SSD 9368 – ALEX AVENUE PUBLIC SCHOOL – ENVIRONMENTAL IMPACT STATEMENT (EIS)

Attachment A

- ENVIRONMENT PROTECTION AUTHORITY COMMENTS -

ALEX AVENUE PUBLIC SCHOOL

Figure 11 – Master Plan Option C – Preferred option

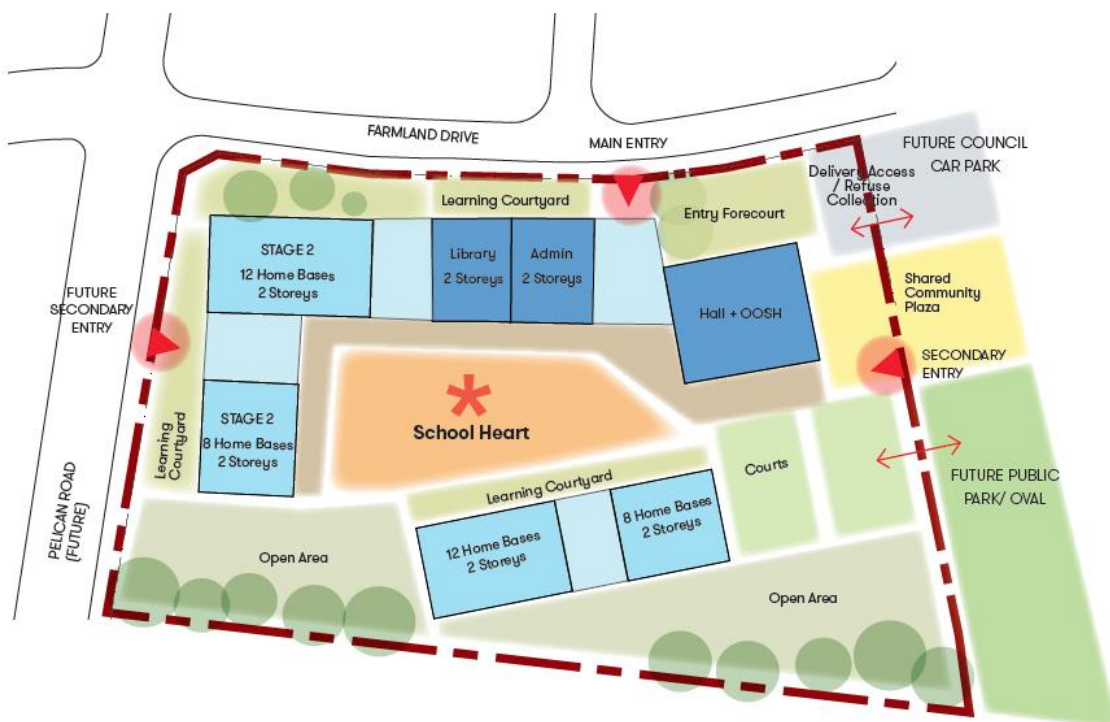
Whilst, EIS Figure 11 indicates that the land adjoining the eastern boundary of the development site is proposed to be developed for the purposes of public open space, the 'Site Features Plan' accompanying EIS Appendix M (Preliminary Environmental Site Assessment) indicates residential allotments along the entire length of the southern boundary.
